Re: Project Name : Big Buck Ridge  
Project File No. : LP-07-00040

We represent the property owners of The Cle Elum Ridge Community and provide these comments with respect to the Notice of Application for performance based cluster plat submitted by Becky Andrus requesting authorization to create 14 one-acre parcels and approximately 11 acres of open space. These comments will supplement comments provided by both clients and adjacent property owners.

RECORDING NO. VOL./PAGE
PORTION OF
NE 1/4 NE 1/4, SEC 26, TWN 20, RGE 15E, W.M.

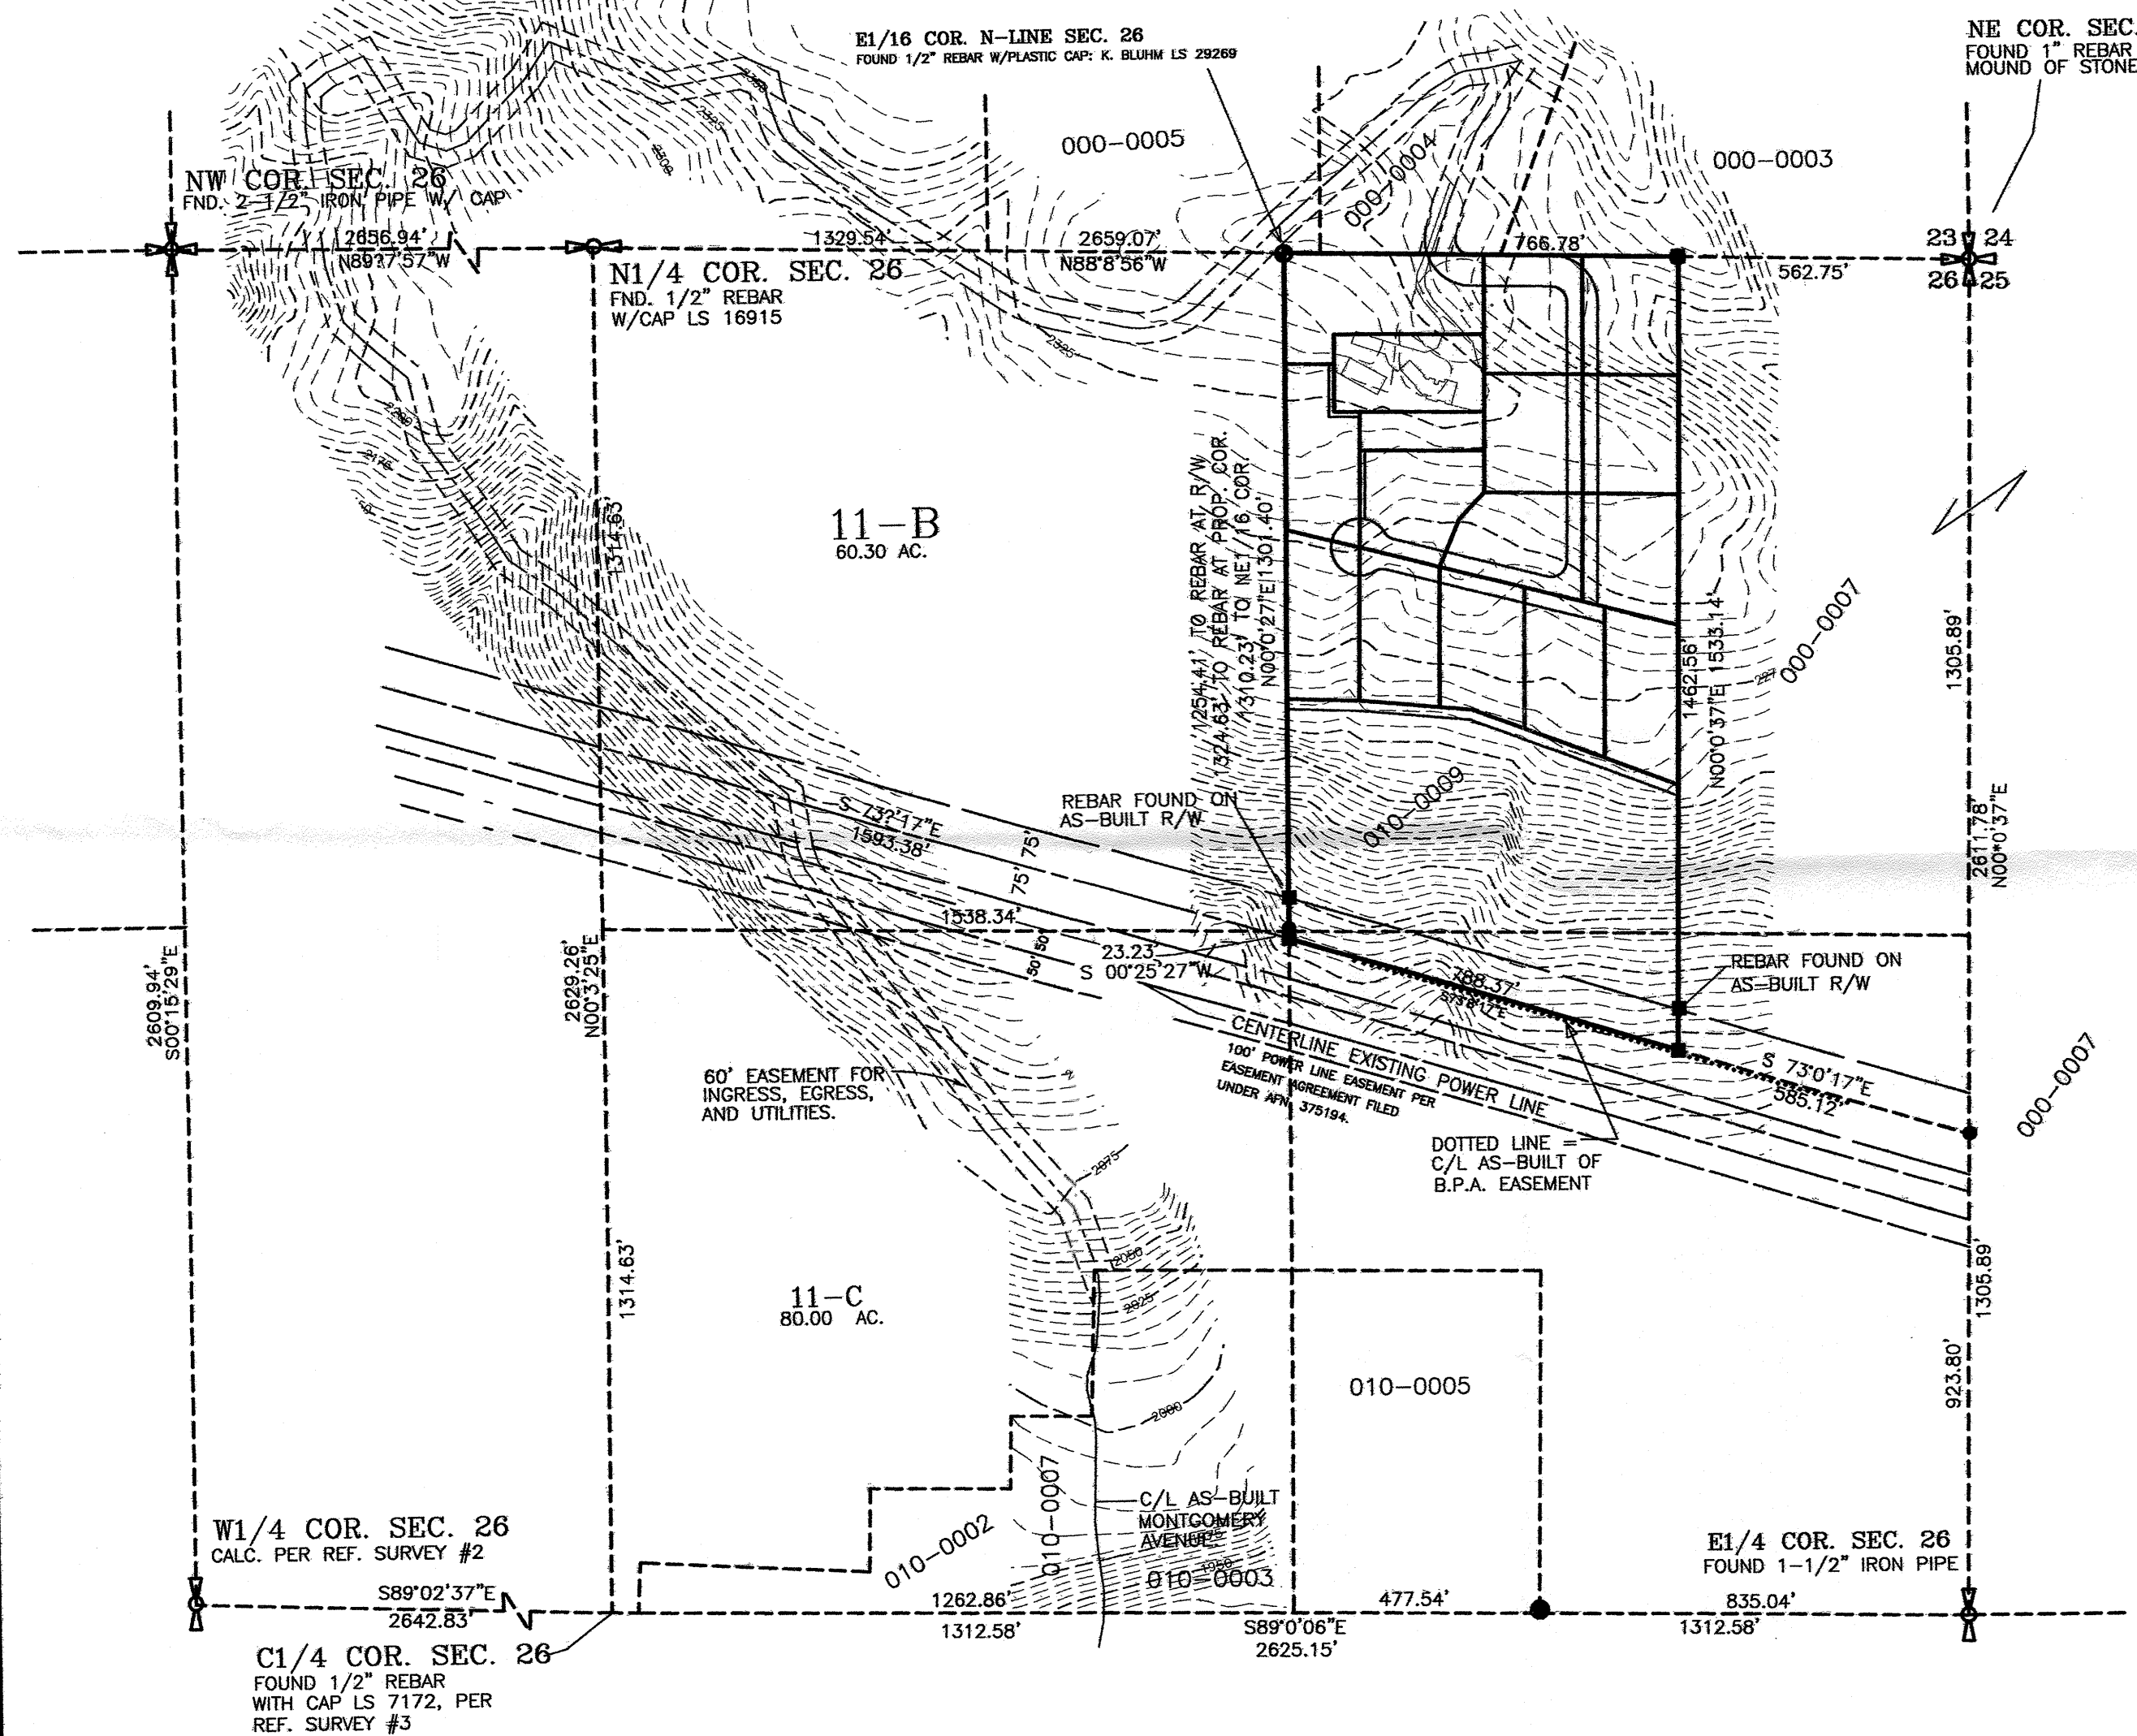
5. Kittitas County (CDS) specifically noted that Deer Creek Road currently serves more than 40 lots and that KCC 12.01.095(2) requires two interconnected ingress-egress routes that independently connect to and on-system county road. KCC 12.01.095(2). Site plan does not show or establish secondary access.
